# **Planning Inspectorate Examination EN010137: Mona Offshore Wind**

**Cefn Meiriadog Community Council  
MNOW-ISP002**

**Deadline 4, 4 November 2024**

## **Submission regarding proposed use of thoroughfare known as 'The Old Lane'**

**Drawing Number:**  
DM\_22000496\_LP\_1.9

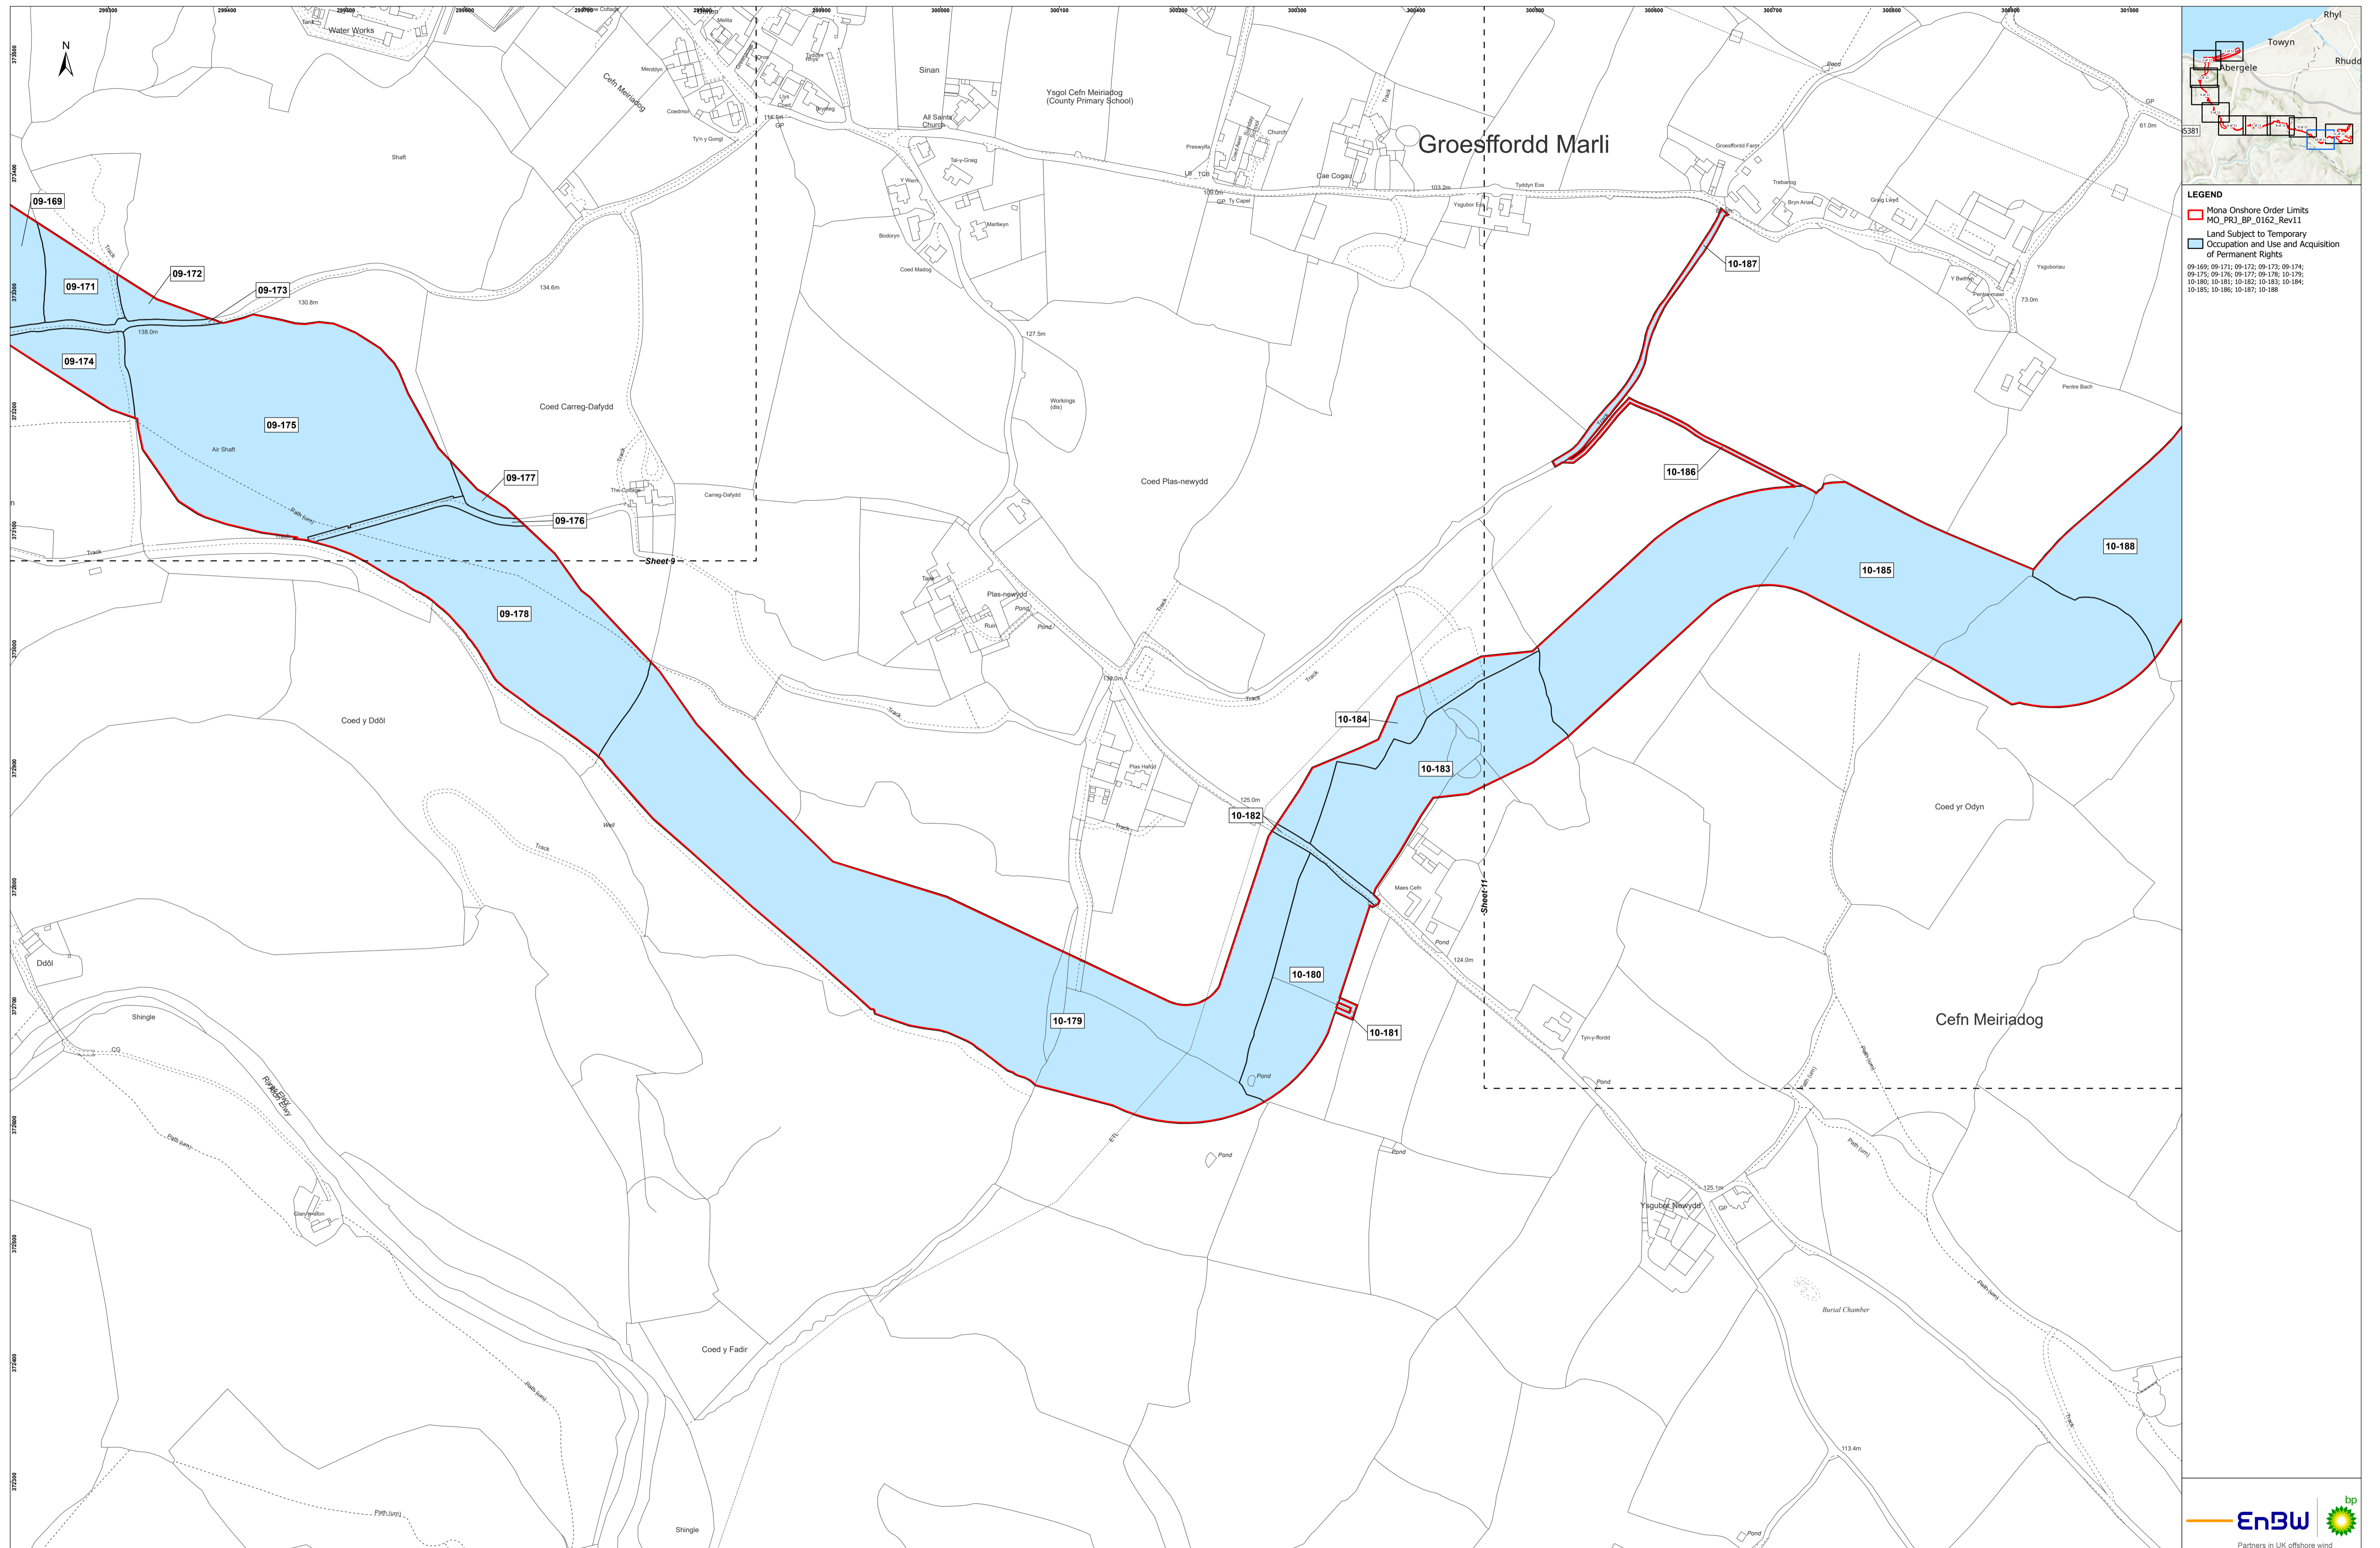
2. The area of land in question is designated 10-187 on Drawing Title Land Plan - Onshore Sheet Number: 10, and is identified as 'Land Subject to Temporary Occupation and Use and Acquisition of Permanent Rights'.

3. It is a narrow unpaved lane running north-east to south-west from the minor road through Groesffordd Marli from near the properties Groesffordd Farm and Trebanog, and providing a link near the properties Plas Hafod and Plas Newydd to the minor road from Sinan church to Cefn and Bontnewydd.

4. The rights that the Applicant is seeking under the Mona Onshore Order Limits cover approximately a third of the lane's overall length, at its north-eastern end close to the properties Groesffordd Farm and Trebanog.

9. It is important to point out that, regardless of its status, the lane is entirely unsuitable for use by large or heavy vehicles of the type that it is assumed that the Applicant would propose to use in accessing the cable corridor, being very narrow with high hedges. An indication of its unsuitability is the fact that access to its adjoining fields by local farmers is limited to quad bikes, and then only occasionally. The lane presents particularly muddy conditions in winter, and its use by vehicles

accessing the cable corridor would render it unusable by walkers, riders and other users from the local community.

10. It is equally important to point out that the minor road through Groesffordd Marli from which access to 'The Old Lane' must be obtained is itself highly unsuitable for large and heavy vehicles and would present severe difficulties for such vehicles and for residents living along the route.

11. For the sake of completeness it should also be pointed out that access point from the lane into the adjacent field shown on the Applicant's Land Plan is in close proximity to sites of exceptionally intense badger activity and extensive setts.

12. On the basis of the above, Cefn Meiriadog Community Council strongly objects to the inclusion of 'The Old Lane' in the Applicant's Onshore Order Limits and requests that it be excluded and that the Applicant be required to find an alternative route.
